Engineers Comments Regarding Surface Water Drainage

Application Reference:	BN/110/25/DOC	Reviewer Reference:	EXT2
Planning Officer:	Hannah Kersley	Date of Review:	18/11/2025
Site Name:	Land South of Barnham Station Barnham		
Application Description:	Approval of details reserved by condition imposed under BN/142/20/OUT relating to conditions 6-surface water drainage and 8-maintenance and management of surface water drainage scheme.		
Assessment Number:	2 of 2

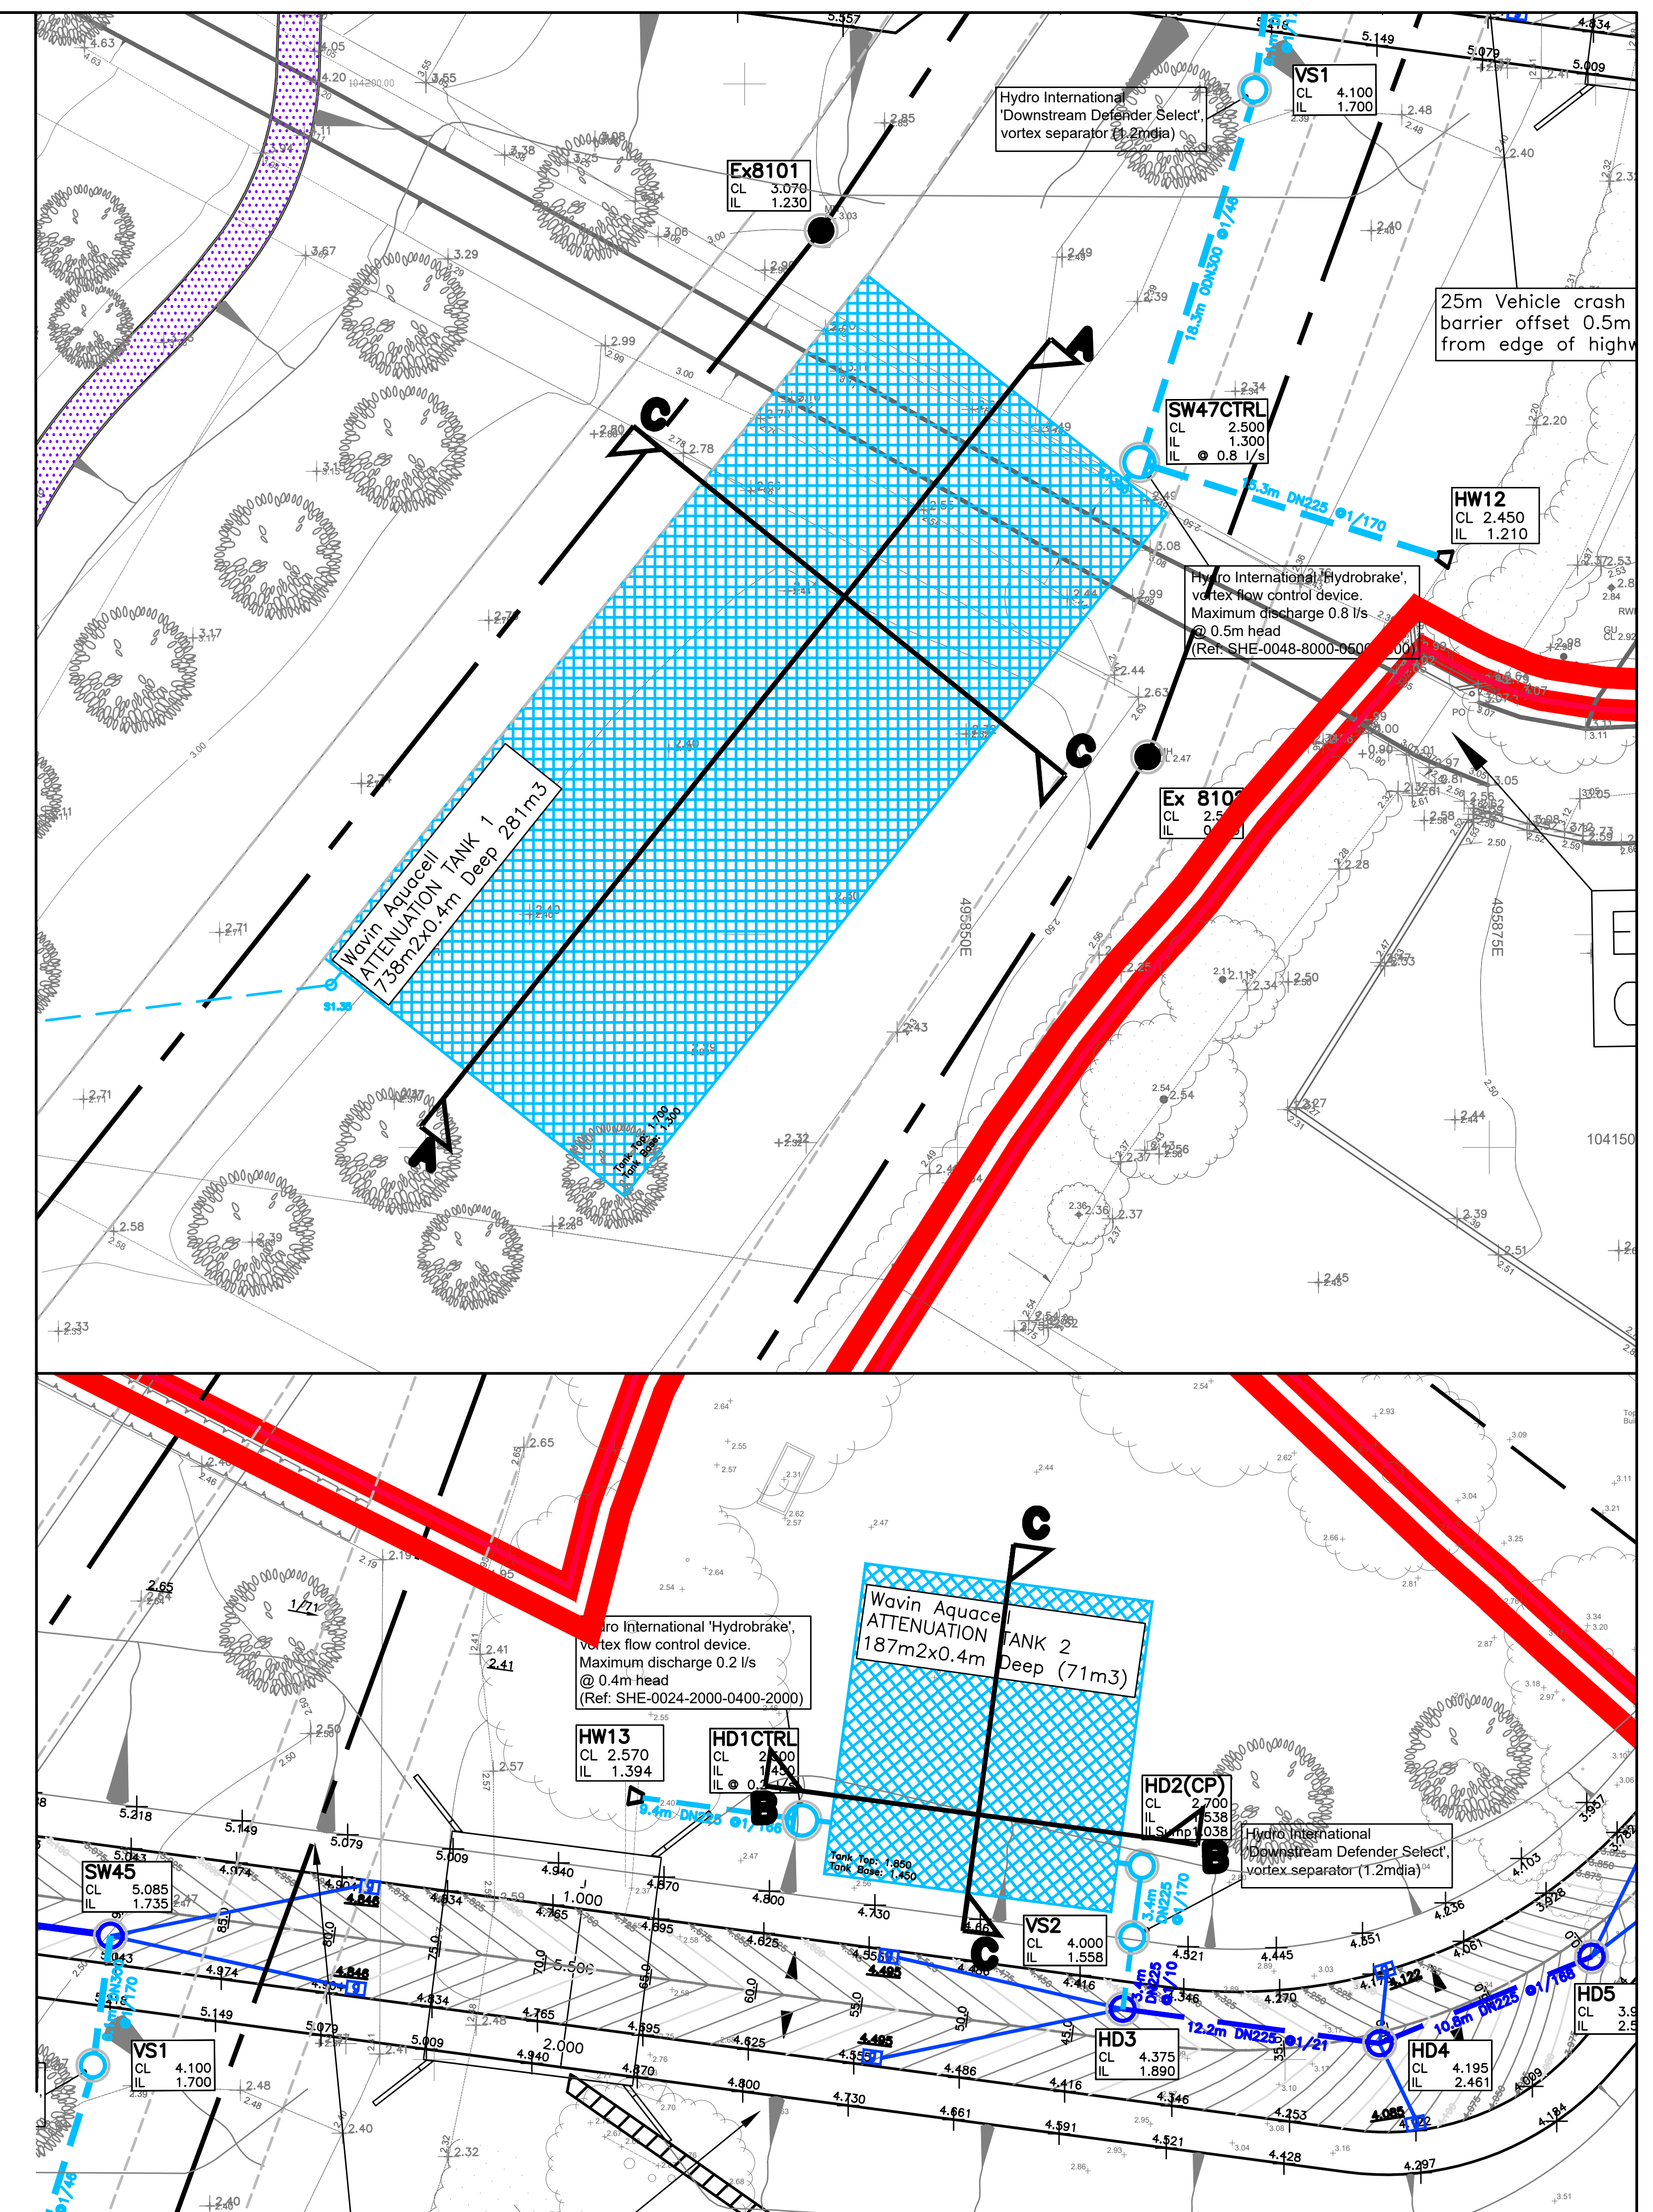
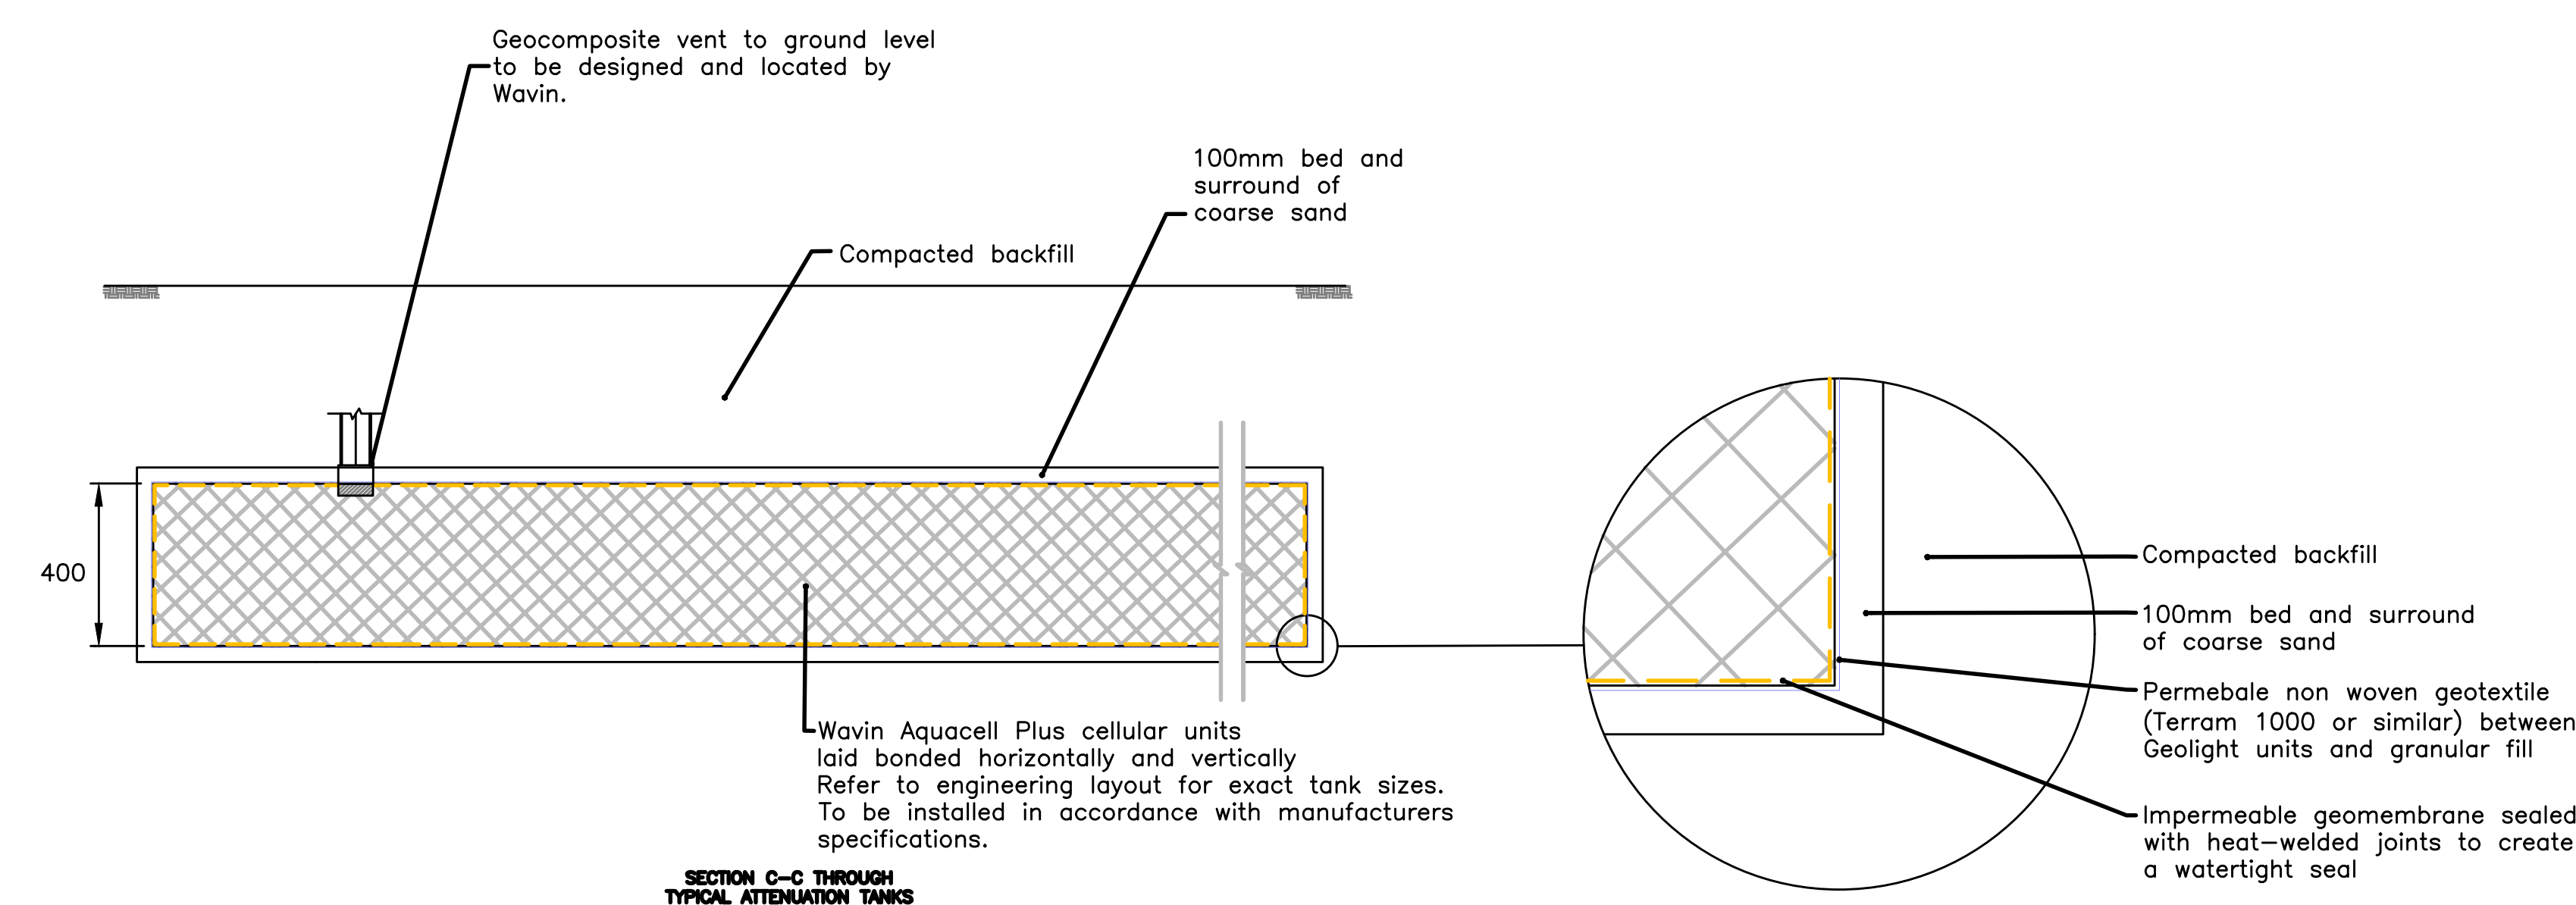
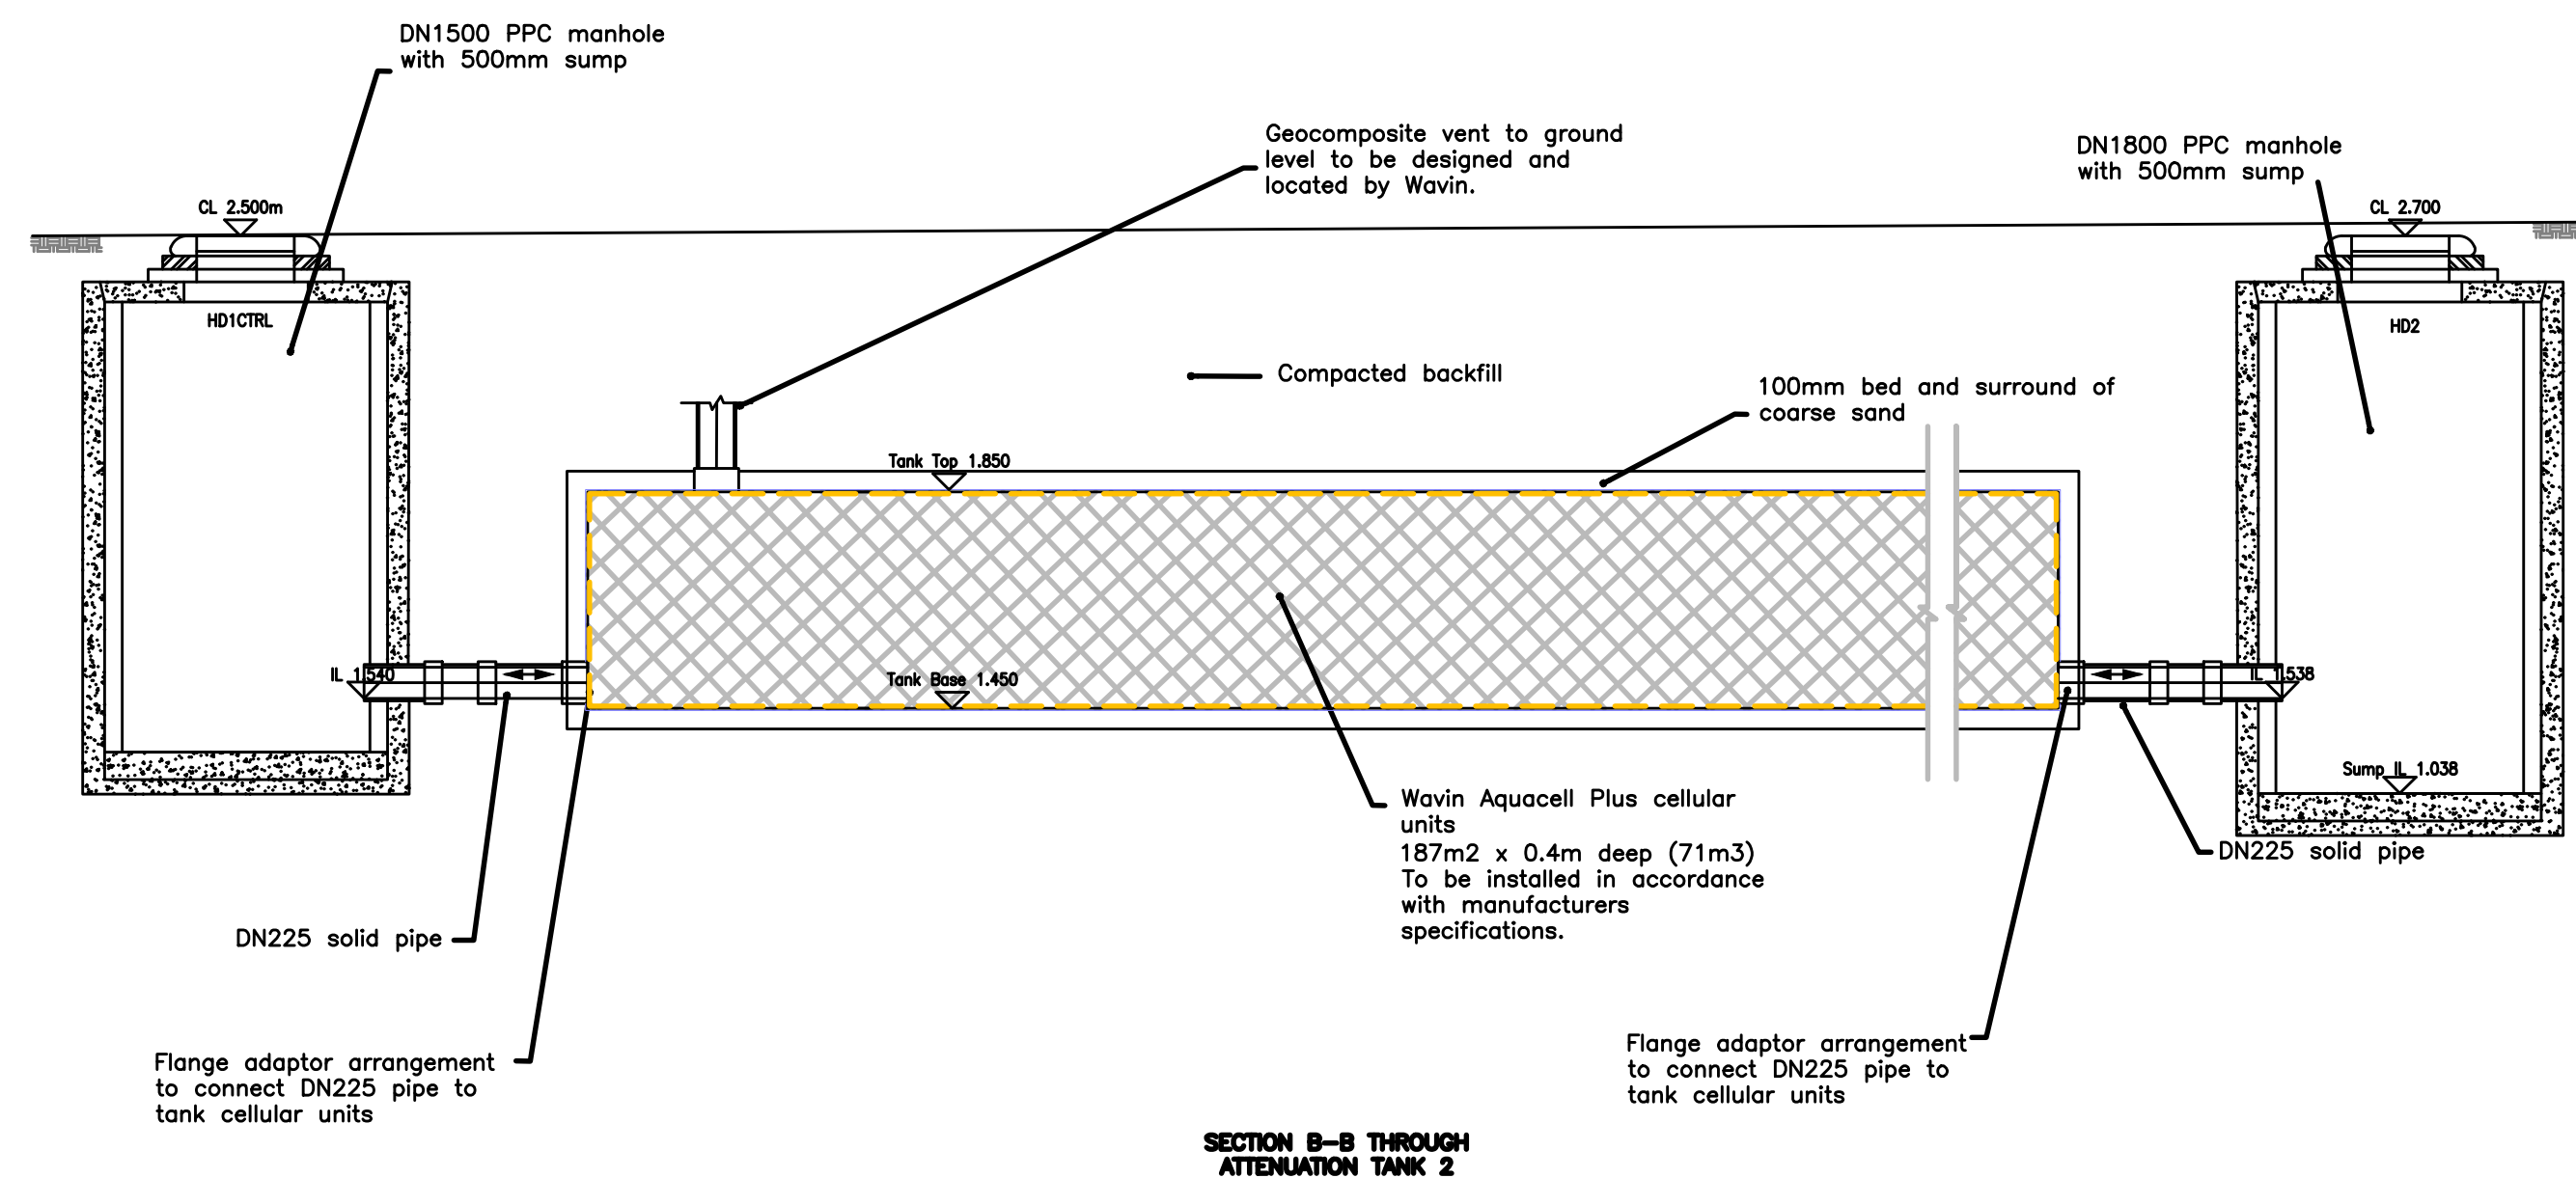
The hydrobrake part reference has now been added to each control and on the engineering plans.				
8. (formally 10)	ADC Further Comments [BN/52/24/DOC] 12/06/2024: The surface water manhole schedule is not consistent with the details in the microdrainage calculations and the overall engineering layout Designer Response [BN/98/24/DOC] 24/07/2024: Schedule now consistent with calcs and layout. Refer to MJA plan 6838-MJA-SW-XX-DR-C-700 P4 ADC Response [BN/98/24/DOC] 03/10/2024: Spot check on SW40, SW41 and SW34 concludes that are still inconsistencies between the manhole schedules/calculations and the overall drainage layout. ADC Drainage Comments [BN/157/24/DOC] 29/04/2025 The manhole schedule is not consistent with the plan. Eg. SW14, SW15 and SW17(CP) cover levels. There are also a number of chambers where the type is incorrectly specified. Eg. control chambers specified as catchpits and Downstream defender chambers specified as standard manholes. Designer Response [BN/157/24/DOC] 16/06/2025 We believe these are all now consistent. Refer to MJA dwg 6838-MJA-SW-XX-DR-C-705_T6 These have been corrected. Designer Response [BN/98/24/DOC] 21/11/2024 Calcs, Schedules and Layouts now all match ADC Drainage Comments [BN/157/24/DOC] 16/01/2025	Drawing 6838-700 P3 has been included in the submission and shows different information to drawings 6836-703 P4 and 705 T6. Should drawing 700 P3 be withdrawn? There are still many chambers where the cover type is not specified on the drawings. SW08 is specified as non-standard 1575mm diameter on drawing 703 P4	Note that both 700 & 703 are superseded by drawing number 705. Please refer to MJA drawing 705 Rev T8 MH Schedule which picks up issues highlighted for point 8.	There are inconsistencies between the manhole schedules and drawing 210-C1. See comment 34

9. (formally 11)	ADC Further Comments [BN/52/24/DOC] 12/06/2024: Flow control chambers and catchpits are noted as standard manhole types on the manhole schedule. Designer Response [BN/98/24/DOC] 24/07/2024: ADC Response [BN/98/24/DOC] 03/10/2024: This can be closed when Item 8 (formally 10) is concluded Designer Response [BN/98/24/DOC] 21/11/2024 N/A Designer Response [BN/157/24/DOC] 17/02/2025 Noted ADC Drainage Comments [BN/157/24/DOC] 29/04/2025 See comments 8 Designer Response [BN/157/24/DOC] 16/06/2025 These have been corrected	As comment 8	Please refer to 705 Rev T8 MH Schedule which picks up issues highlighted.	There are inconsistencies between the manhole schedules and drawing 210-C1. See comment 34

34. (formally 42)	ADC Response [BN/98/24/DOC] 03/10/2024: Please provide the detailed design prepared by SDS Ltd noted on drawing 210. Designer Response [BN/98/24/DOC] 21/11/2024 Tank type changed to Wavin Aquacell. Construction drawings will be issued by Wavin upon receipt of	Whilst a description has been provided for connecting 225 diameter pipes to the storage tank,	Please refer to drawing 210_C1 which shows construction detail of tank and notes the inclusion of a flange adaptor arrangement	Drg 210-C1: Tank 1 Outlet is noted as 300 diameter and 225 diameter

Tank 2 Chamber diameters are different to schedule HD1CTRL IL shown on pipe is different to schedule and above tank base HD1 drawn as catchpit but it is a flow control chamber Detail regarding vent unclear. More detail required.	
35.	ADC Drainage Comments [BN/157/24/DOC] 16/01/2025 A statement is included in the submitted Technical Note regarding water quality but no evidence is provided to demonstrate compliance with the various documents listed. Please demonstrate compliance. Designer Response [BN/157/24/DOC] 17/02/2025 Can you please clarify what additional evidence you need to demonstrate compliance?	Additional information provided. Comment closed.

order. ADC Drainage Comments [BN/157/24/DOC] 16/01/2025 Please provide the detailed design referred to on the drawing. Designer Response [BN/157/24/DOC] 17/02/2025 MJA drawing 6838-MJA-SW-XX-DR-C-210_P5 is sufficiently detailed to tender and construct from. Note on drawing amended to 'To be constructed in accordance with manufacturers installation specifications.' ADC Drainage Comments [BN/157/24/DOC] 29/04/2025 The status of this drawing is preliminary making it subject to changes. Please provide a Construction Issue drawing. Details must be provided of how larger diameter pipes will be connected to the product, which have 150mm diameter preformed connectors. If this requires a manifold of multiple 150mm diameter pipes, this must be reflected in the calculations and shown on drainage plan Designer Response [BN/157/24/DOC] 16/06/2025 A Flange Adaptor can be used to connect up to a DN225 pipe to the aquacell unit. The DN300 pipe linking Tank 1 to SW47CTRL has been reduced to a DN225 pipe and calcs updated to suit.	the drawings have not been updated to communicate this to the contractor. A detail must be provided on the drawings.	to facilitate the DN225 pipe connection to the cellular tank.	Both chambers noted as SWCTRL47 (should there only be 1 chamber?) SW47CTRL drawn as catchpit but its a flow control chamber Chamber diameter is different to schedule IL on pipe not readable Sump level of 0.898 appears to be incorrect (not consistent with 500mm deep sump) Detail regarding vent is unclear. More detail required.
